## 4-Square at Sterling Ranch East Traffic Technical Memorandum (LSC #S224590) November 22, 2022

RE: 4-Square at Sterling Ranch East  
El Paso County, CO  
Traffic Technical Memorandum  
LSC #S224590

STERLING RANCH EAST
PRELIMINARY PLAN NO. 2
PUD DEVELOPMENT PLAN &
PRELIMINARY PLAN

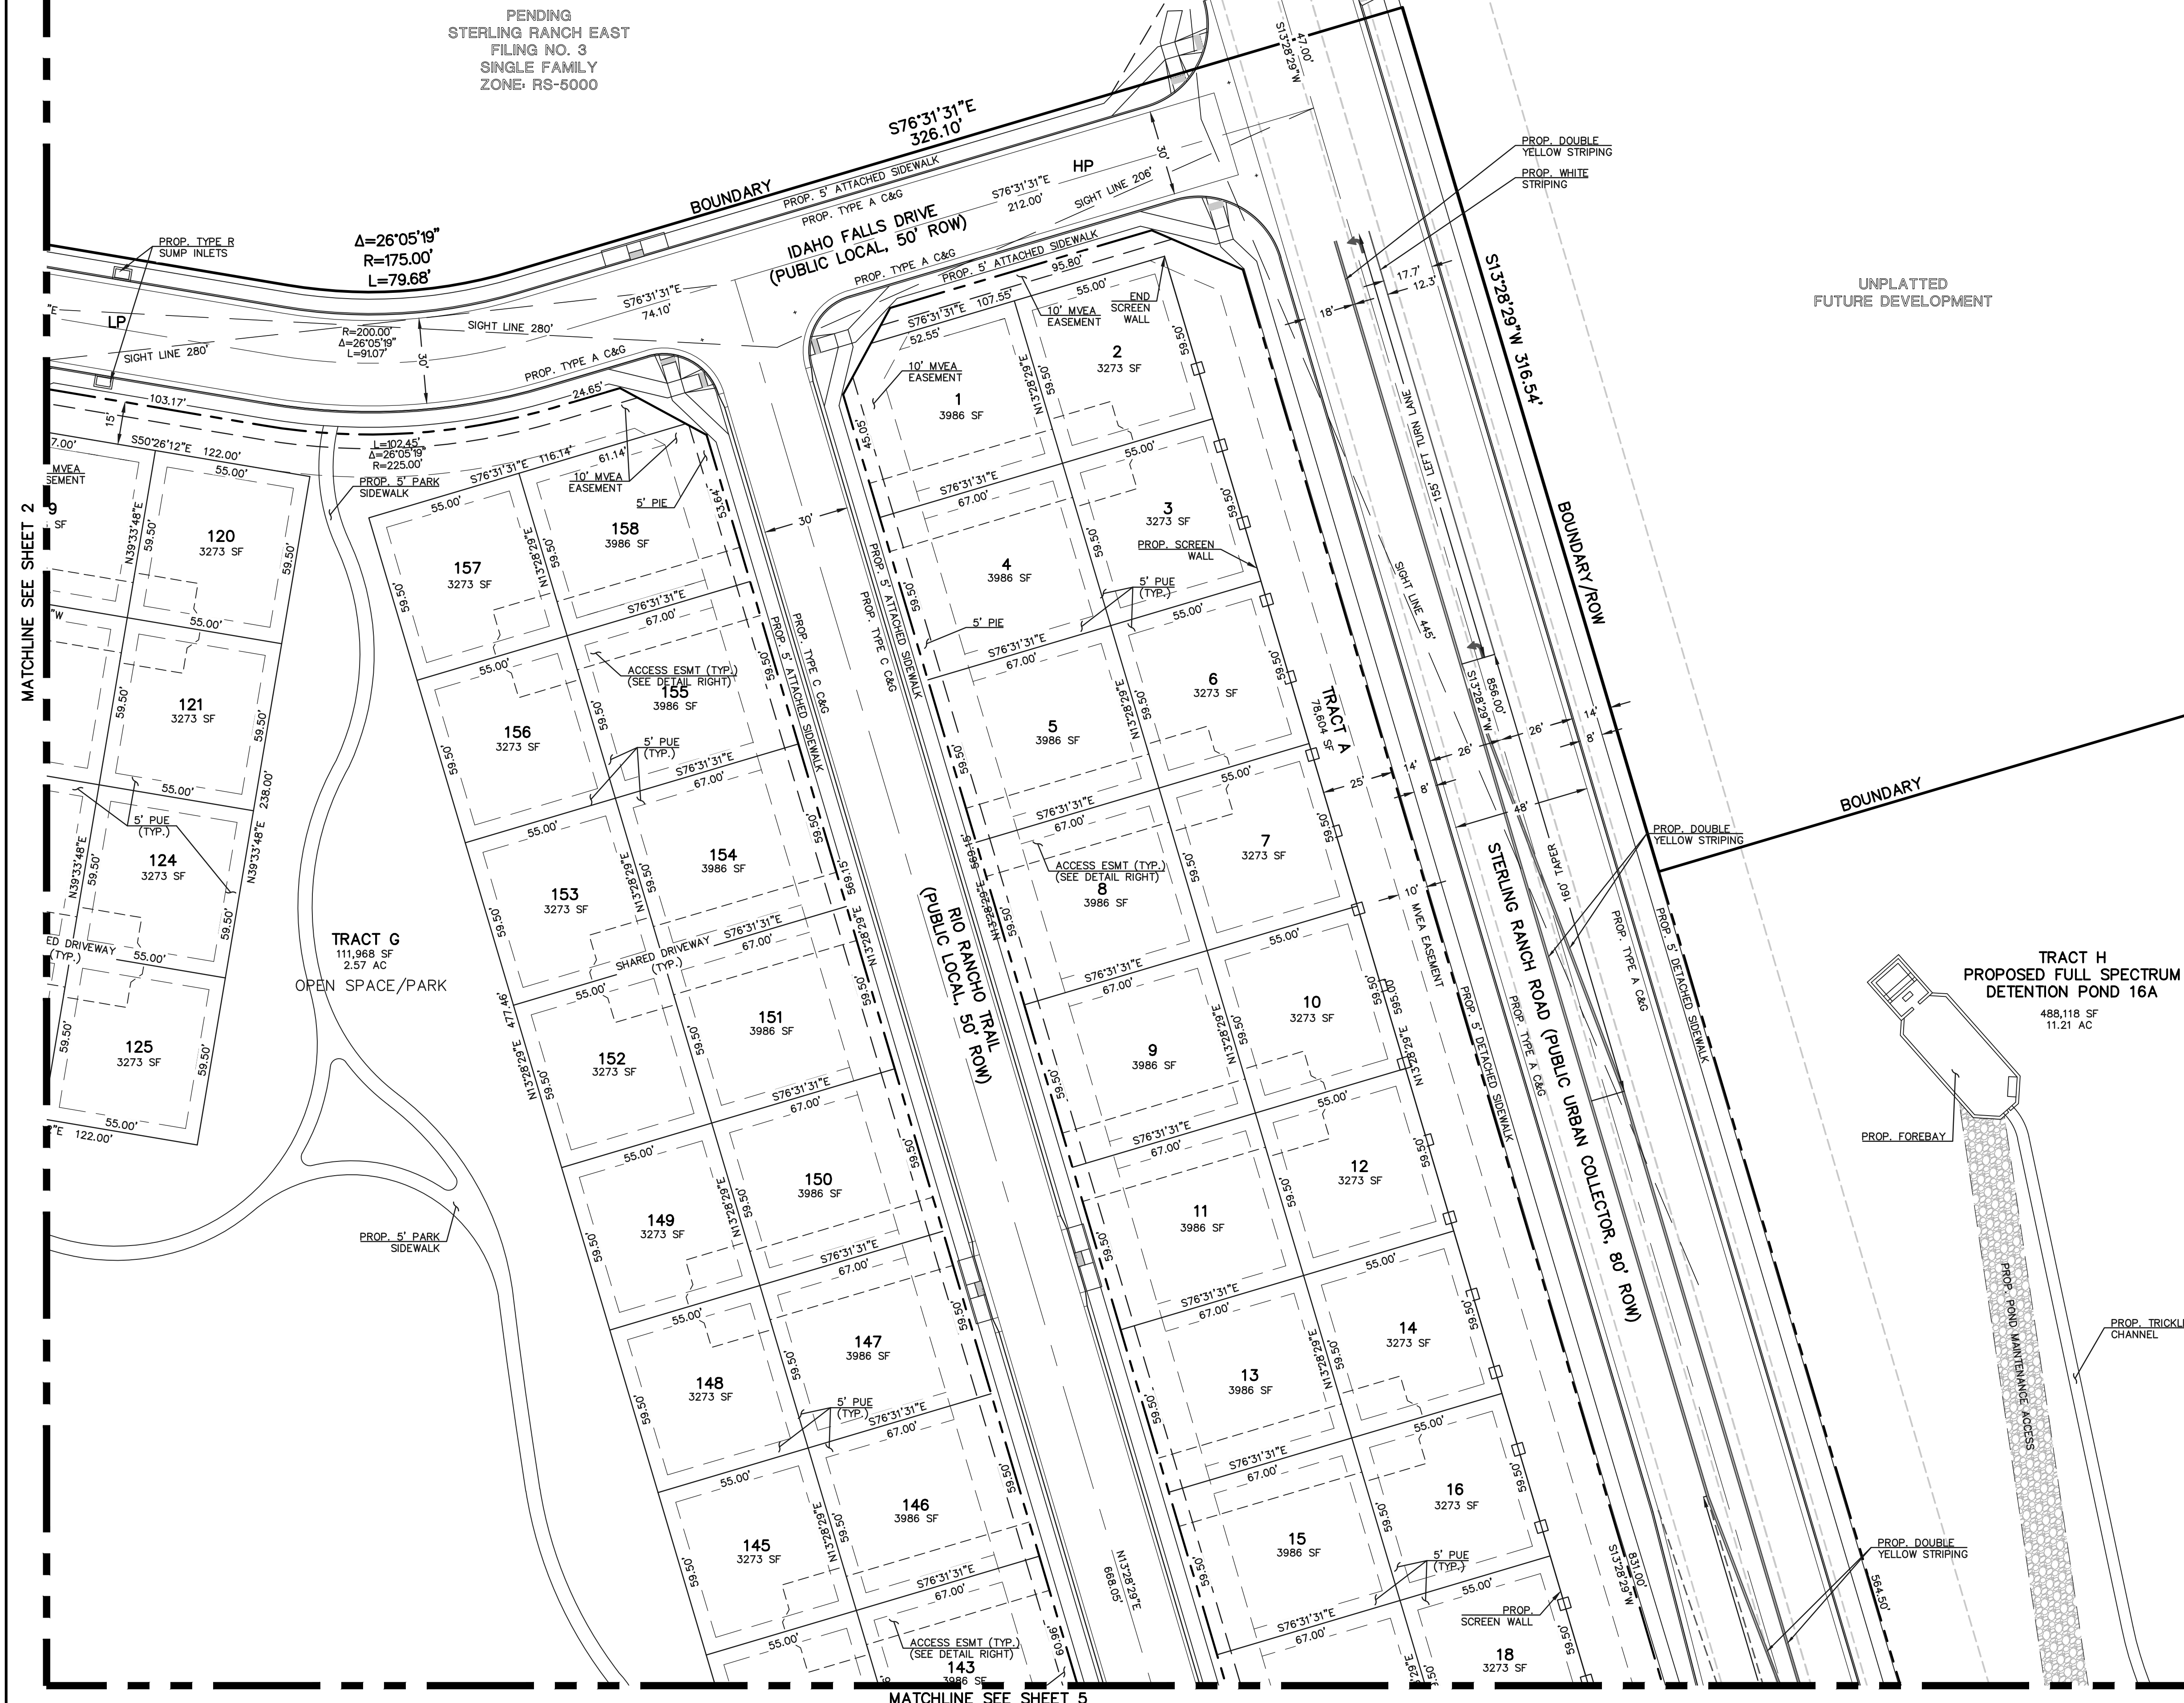
The site plan does not reflect a typical single family home lot layout, as many lots do not front on roadways. Please clarify land use.

Address internal sight distances. Some do not meet the 280' minimum (previous PUDSP redline)
